City of Albuquerque

RE: ENGINEER'S CERTIFICATION FOR ALAMO RENT-A-CAR
(M-16/D28) ENGINEER'S CERTIFICATION DATED JANUARY 29, 1991

RECEIVED REVISOR'S REVISED DRAINAGE PLAN FOR ALAMO RENT-A-CAR (M-16/D28) RECEIVED
DECEMBER 24, 1990

RE: REVISED DRAINAGE PLAN FOR ALAMO RENT-A-CAR
(M-16/D28) RECEIVED OCTOBER 22, 1990

**GRADING & DRAINAGE PLAN
ALAMO RENT-A-CAR**

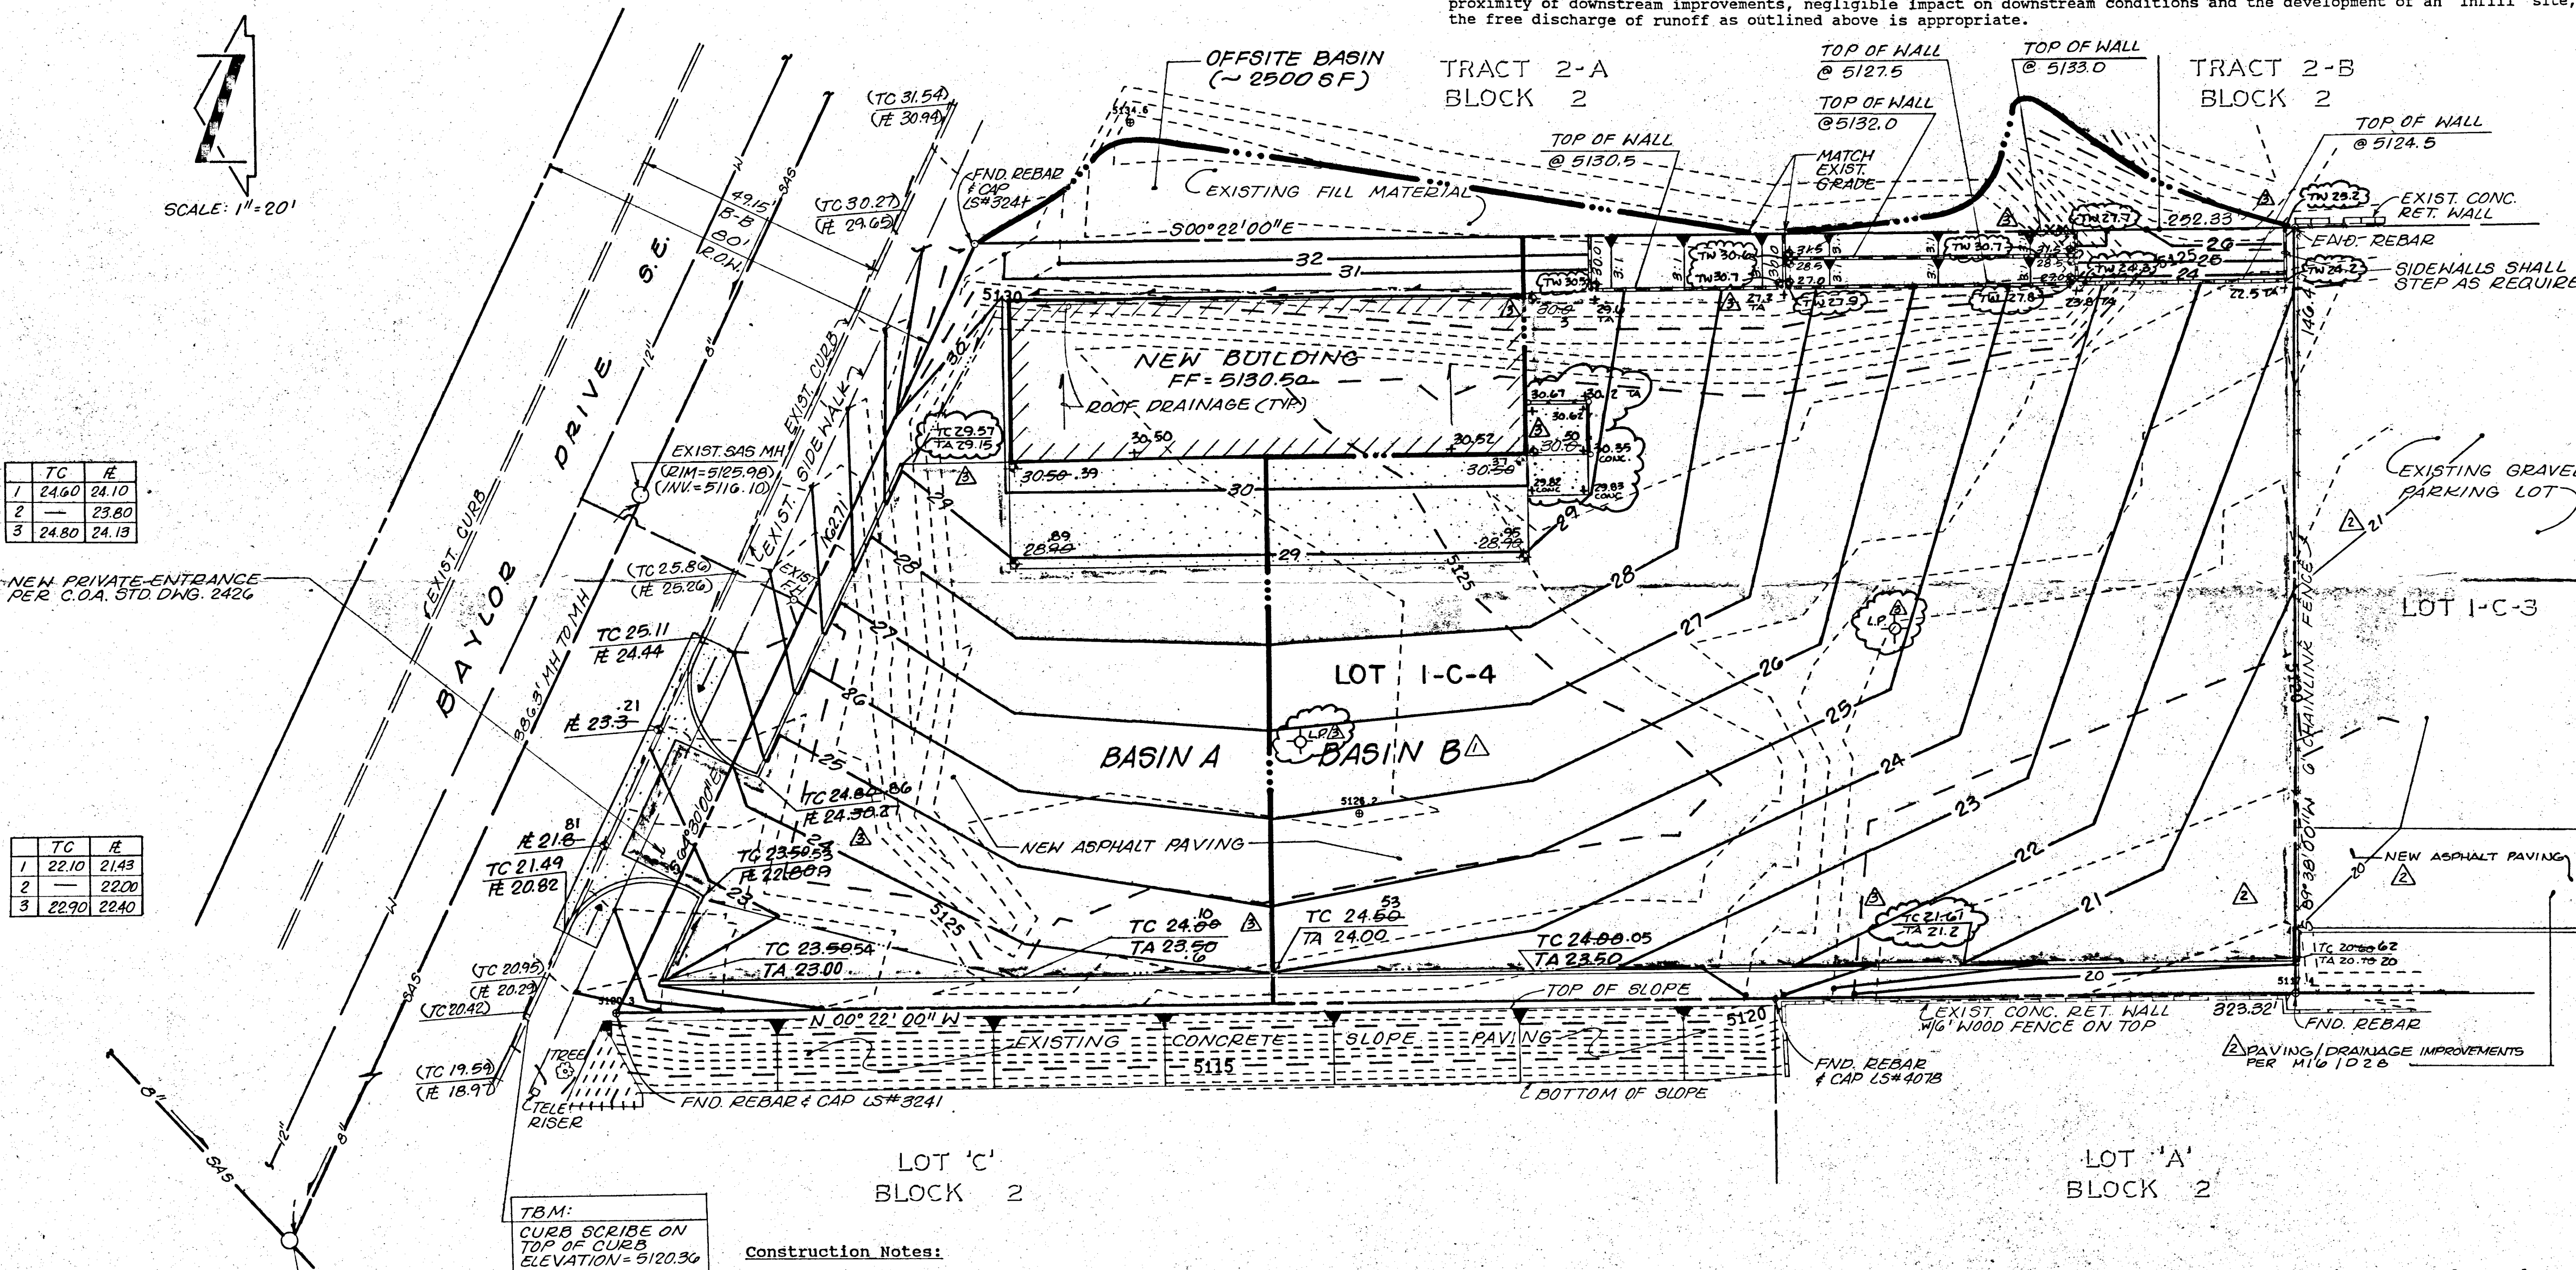
1. You will need to provide an easement for cross-lot-line drainage on Lot 1-C-3.
2. A concrete or asphalt channel must be provided to convey Basin B through Lot 1-C-3.
3. You must also provide documentation that downstream capacity exists.
4. If the building permit has already been released, it will be your responsibility to see that the contractor does not grade the lot per the revised plan until it has been resubmitted and reviewed by our office.
